**Kemps Creek Warehouse, Logistics and Industrial Facilities Hub (SSD-9522-Mod-2)
Request for additional information**

I refer to the Modification Report for the Kemps Creek Warehouse, Logistics and Industrial Facilities Hub (SSD-9522-Mod-2).

The Chief Engineer has carried out a review of the documents provided in support of the modification application. The comments provided by the Chief Engineer dated 13 August 2021 are considered addressed. However, the following comments require additional information:

DRAWING No	C013362.00- DA03	ISSUE	A
------------	------------------	-------	---

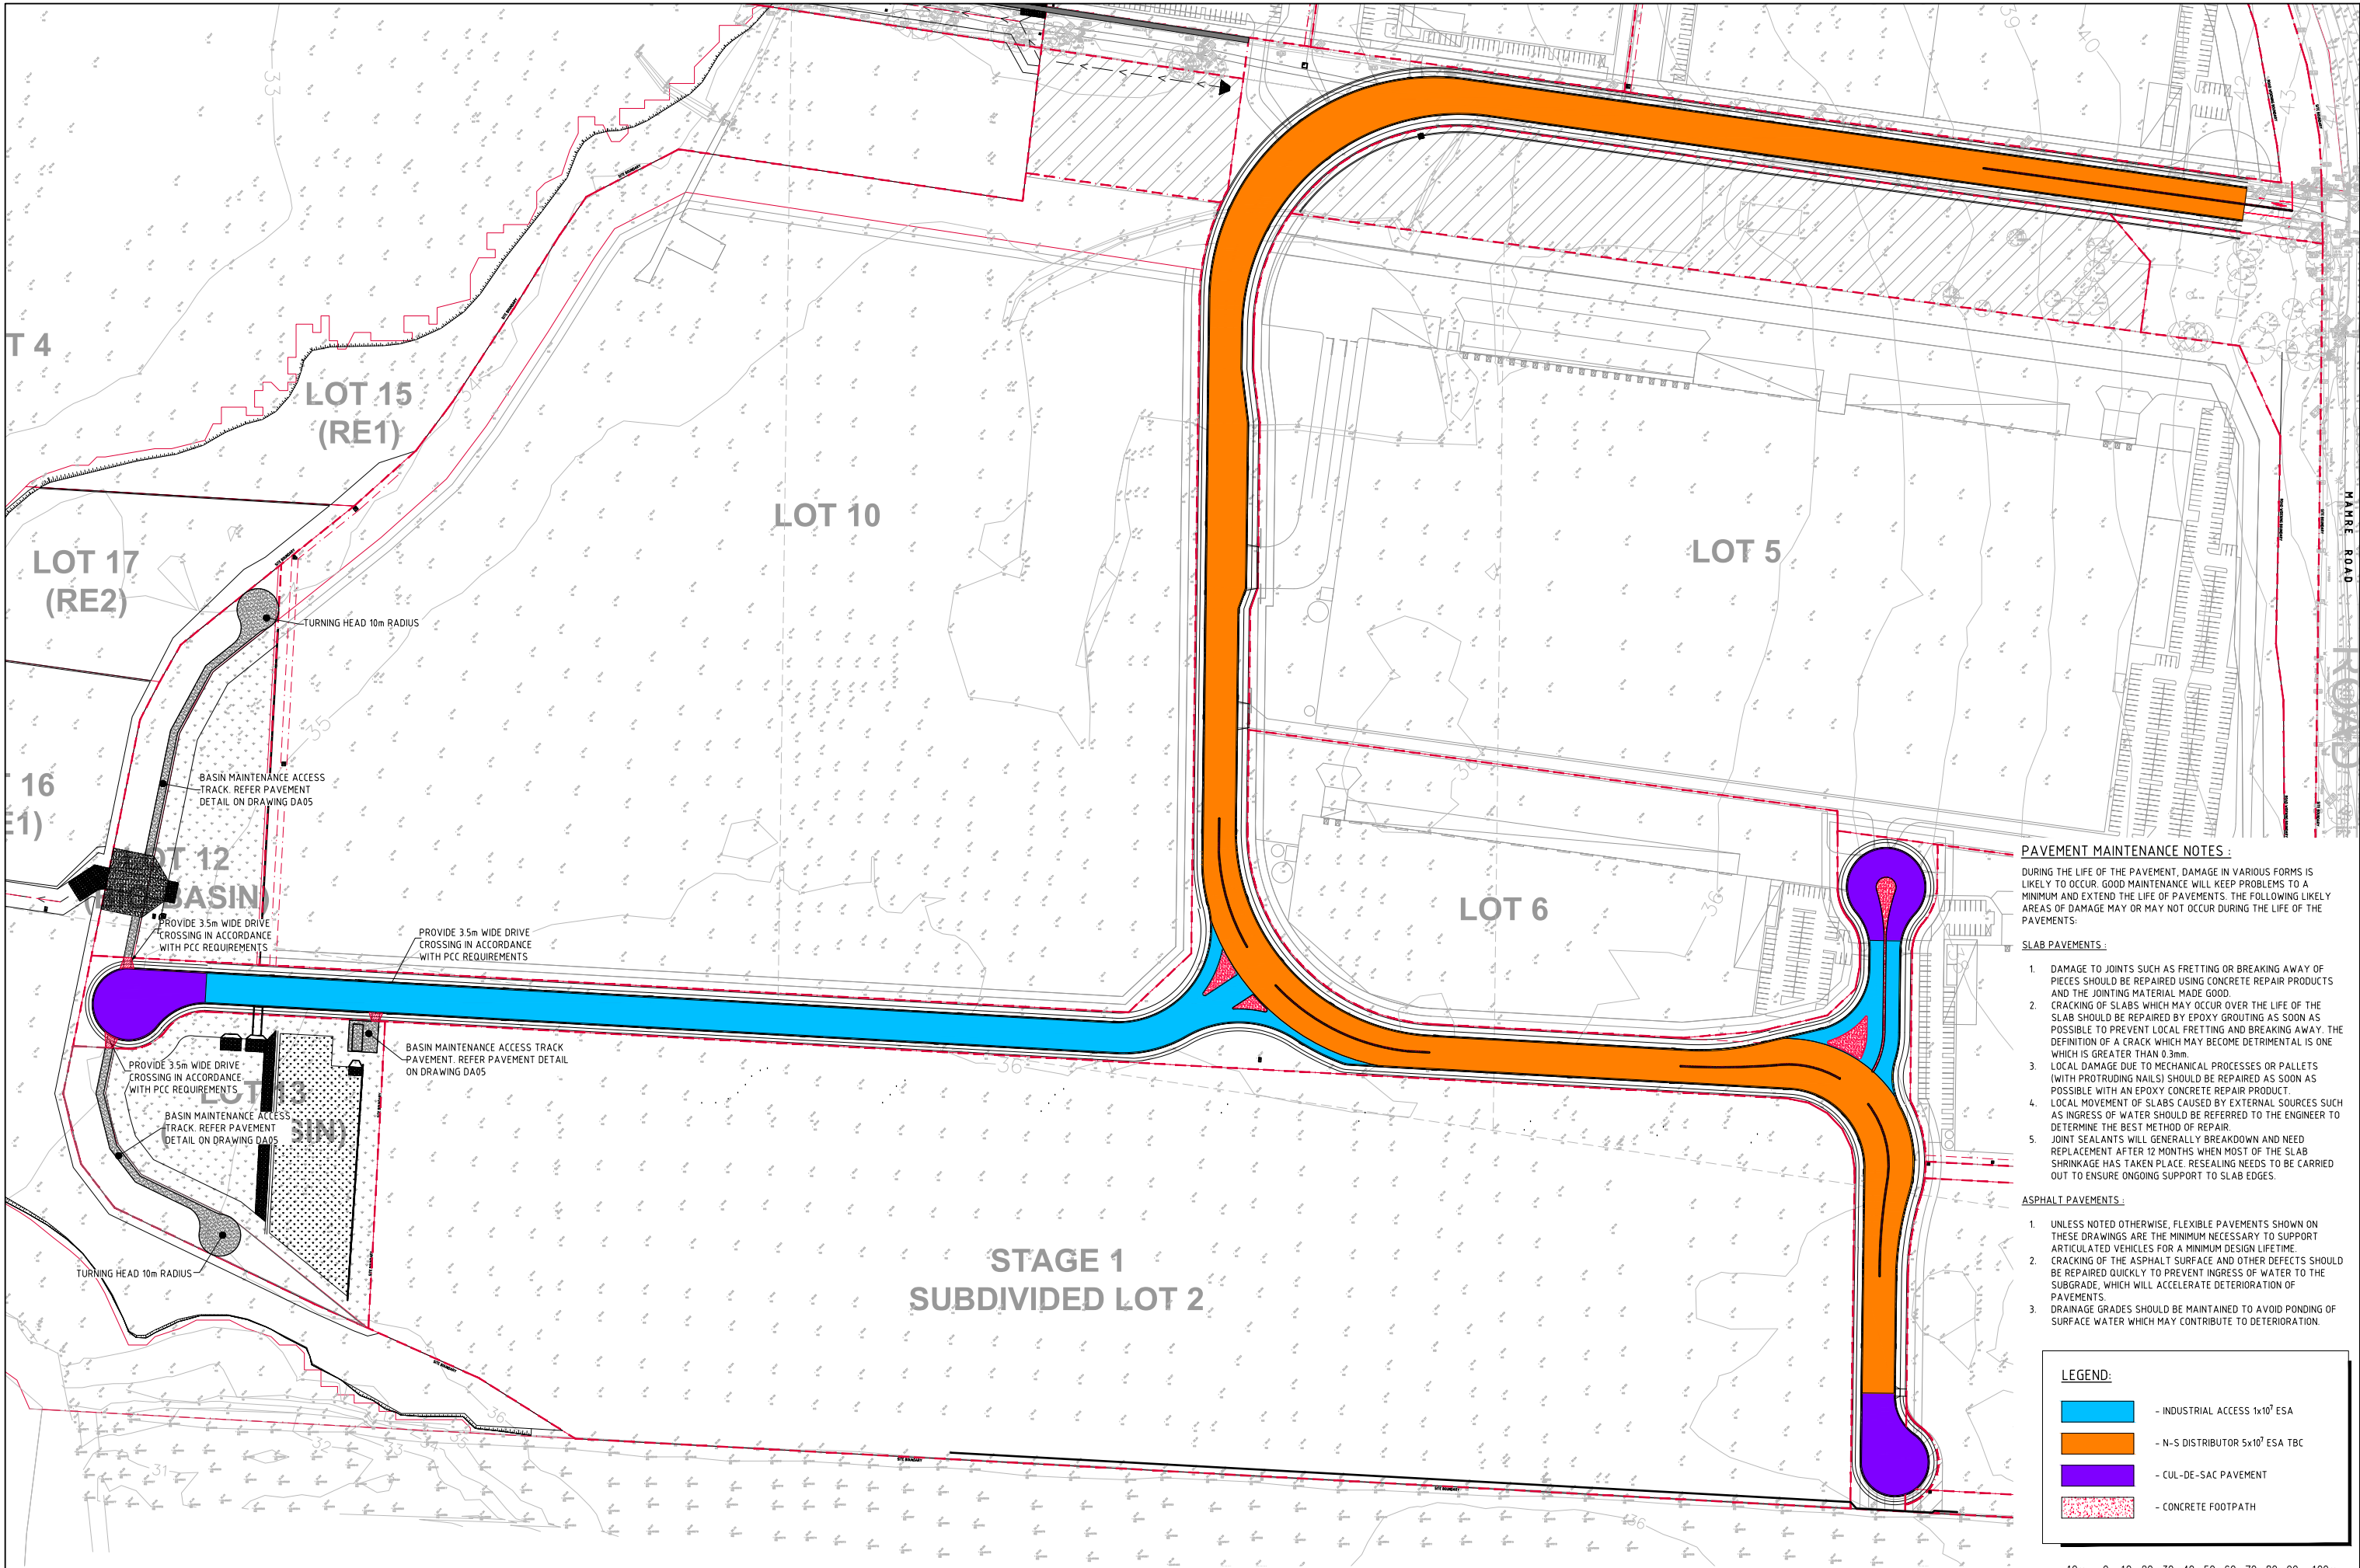
- The proposed amendments to the road reserve, as summarised in the table titled 'Estate Road Cross Section per SSD 9522' on page 14 of the Modification Report dated 19 October 2021, have not been modified in the civil drawings. Drawing CO13362.00 – DA 04 Issue B does not depict the modified road widths (Section 2). This error is carried into other civil drawings (CO13362.00 – DA08 Issue C) used in the swept path analysis. These errors need to be addressed and the swept path analysis reassessed with the agreed road widths.
